Item No. **Report of the Head of Planning, Transportation and Regeneration**

Address 30 THE LARCHES HILLINGDON

Development: Part two storey, part single storey rear extension and single storey side/rear extension

LBH Ref Nos: **70680/APP/2019/1947**

DRAWN	AS	SCALE @ A3
DATE	APRIL 19	1:100
DRAWING NO.	REV.	
AS01119-05	A

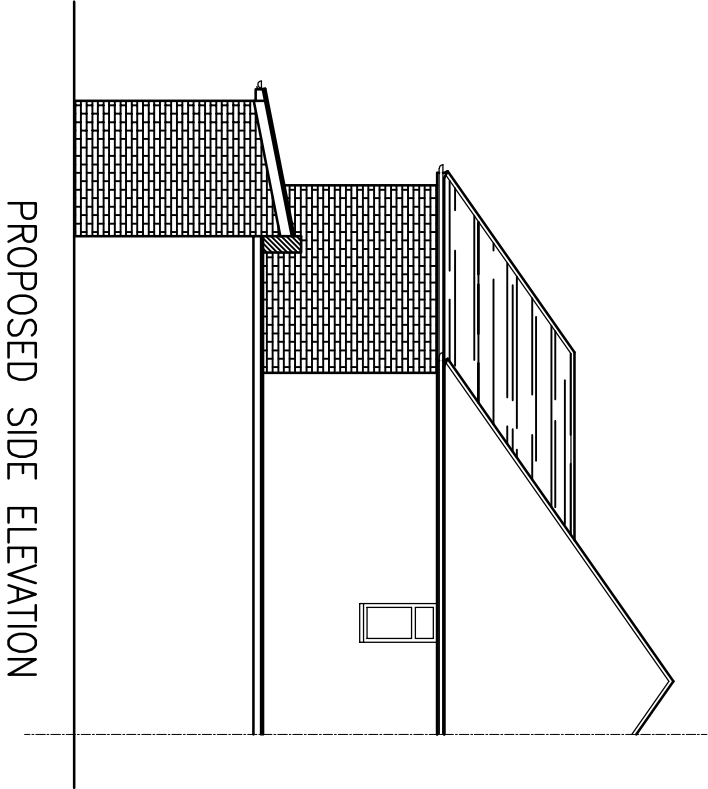
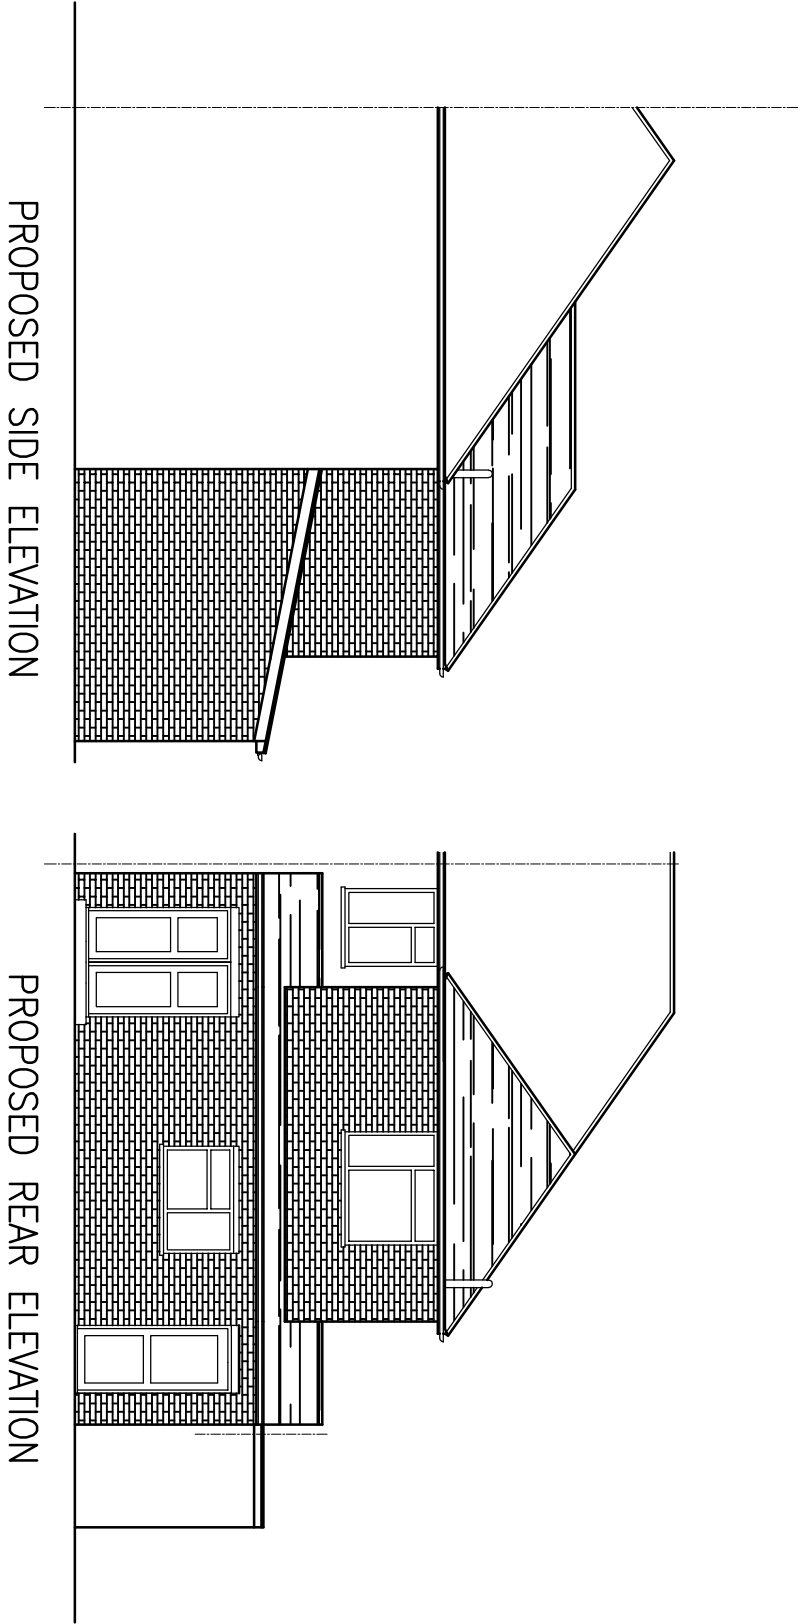
During the determination process the plans were amended to correct an error on the plans.

Section 6 of the Hillingdon Design and Accessibility Statement: Residential Extensions (HDAS) states that two storey rear extensions on semi-detached houses should not exceed 3.6 metres in depth. Two storey elements should be set down from the ridge of the main dwelling by a minimum of 0.5 metres and the roof should be of similar design to the existing. Any extensions at first floor level should not extended beyond 45-degree line of sight taken from the nearest of the first floor window of any room of the neighbouring property. Section 3 adds that single storey elements should not exceed 3.4 metres in height if a pitched roof is proposed and Section 4 states side extensions should not exceed two thirds of the width of the original dwelling house.

AS01119-04

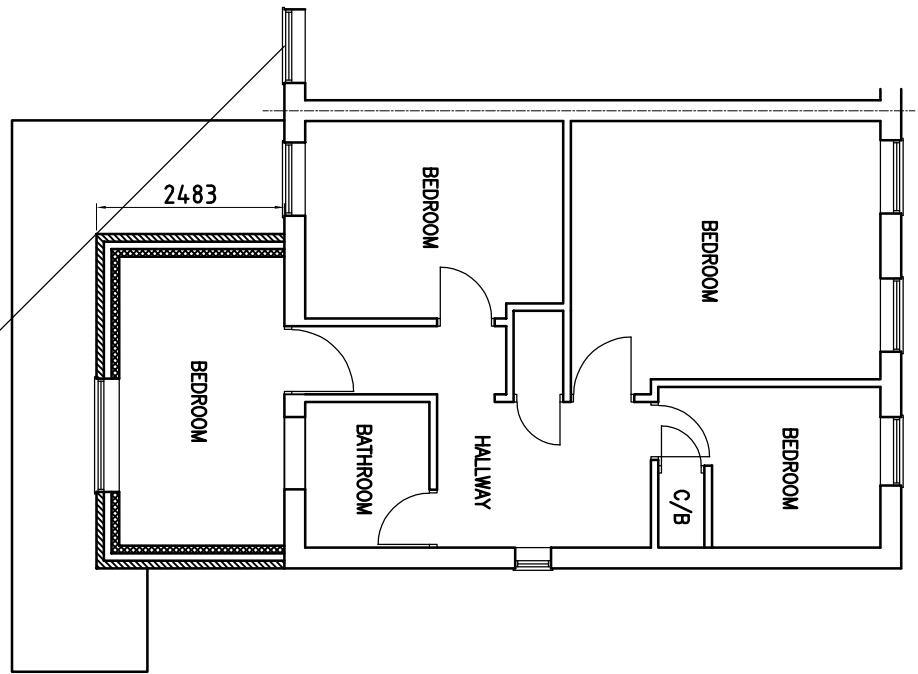
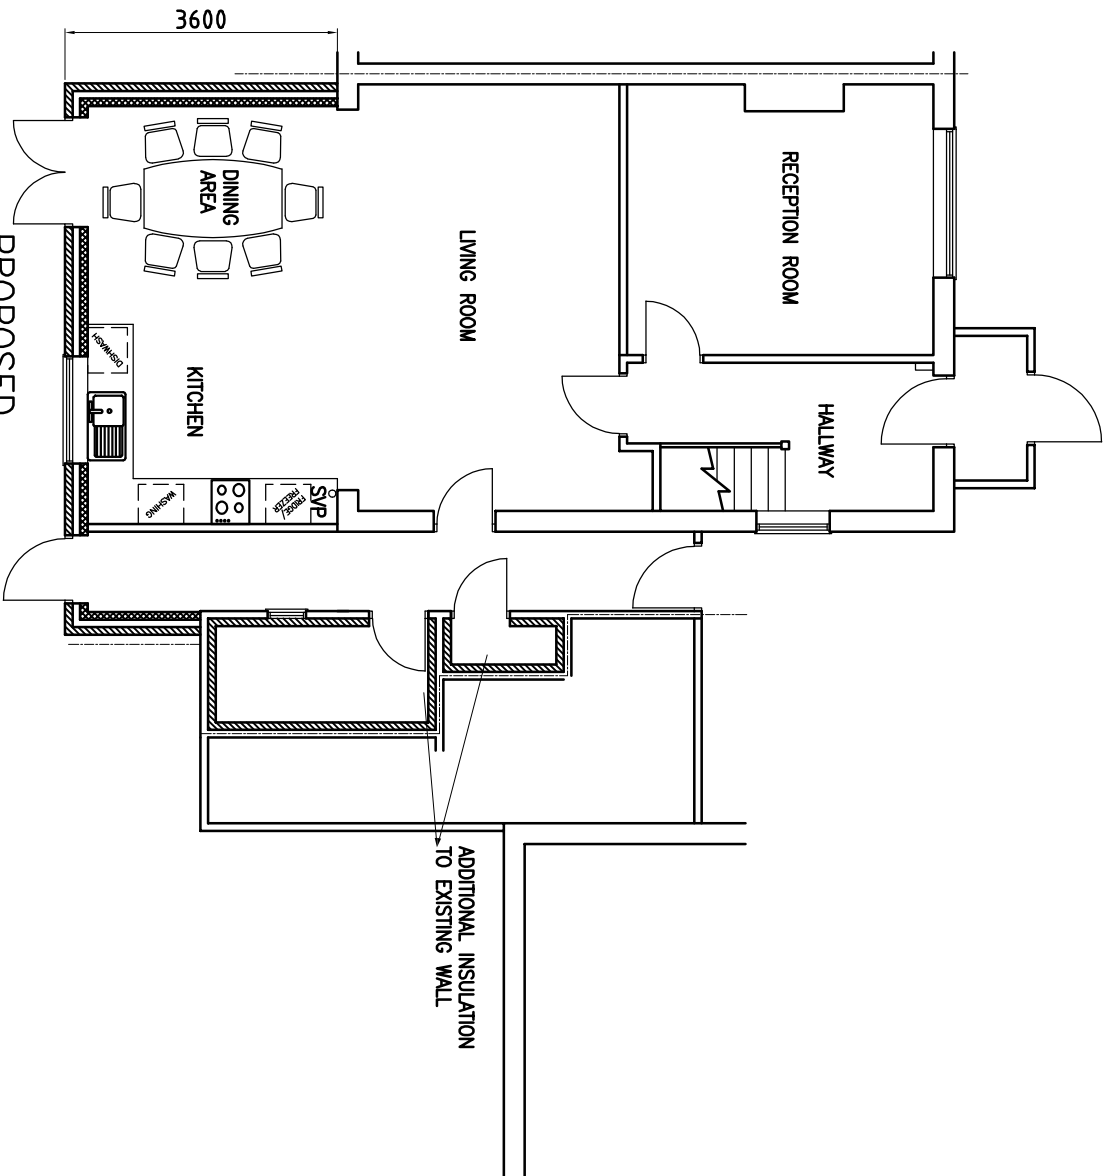
The single storey side/rear extension would project to the side of the dwelling house by 1.5 metres which would equate to 25% of the original property. It would be located behind the existing covered walkway and outbuilding and so would not be visible from the public domain. The two storey extension would be located to the rear of the property and would have a maximum depth of 3.6 metres which is reduced to 2.483 metres at first floor. The two storey element would be set down from the ridge by 1.5 metres and the single storey element would have a maximum height of 3.3 metres. As such, the proposal would comply with HDAS recommendations and so it is considered that it would appear subordinate to the main dwelling house. As the extension would be located to the rear it would not be overly visible from the street scene and it is considered that it would not appear dominant within the street scene and would not have a negative impact on the uniformity of the properties along The Larches. Subsequently, it is considered that the proposal would comply with Policies BE13, BE15 and BE19 of the Hillingdon Local Plan: Part Two - Saved UDP Policies (November 2012).

The ground floor extension would be built up to the shared boundary line with No.28 The Larches. This neighbour has not been extended, and so the ground floor element would project to the rear of this property by 3.6 metres. However, as this complies with HDAS recommendations it is considered that it would have an acceptable level of impact on this property. The first floor element would be located 1.6 metres from the shared boundary line and the plans demonstrate that it would not intersect the 45 degree horizontal line. In addition, No.28 is located to the South of the application site and so there would be a limited impact on sunlight to this neighbour.

The extension would be built up to the shared boundary line with No.32 at ground floor and would be set back from the boundary by 1.5 metres. No.32 is set further forward than the application property and so the rear extension would project to the rear of this neighbour by 5.8 metres at ground floor and 4.6 metres at first floor. However, there is a shared outbuilding located between the two properties which projects to the rear of No.32 by 4 metres and as such it is considered that the ground floor element which would be 1.8 metres to the rear of this outbuilding and 2.5 metres from the neighbouring building would not have any additional detrimental impact than the existing situation. In addition, due to the distance between the two properties, the first floor extension would not intersect the 45 degree horizontal line. No side windows would be installed as part of the proposal.
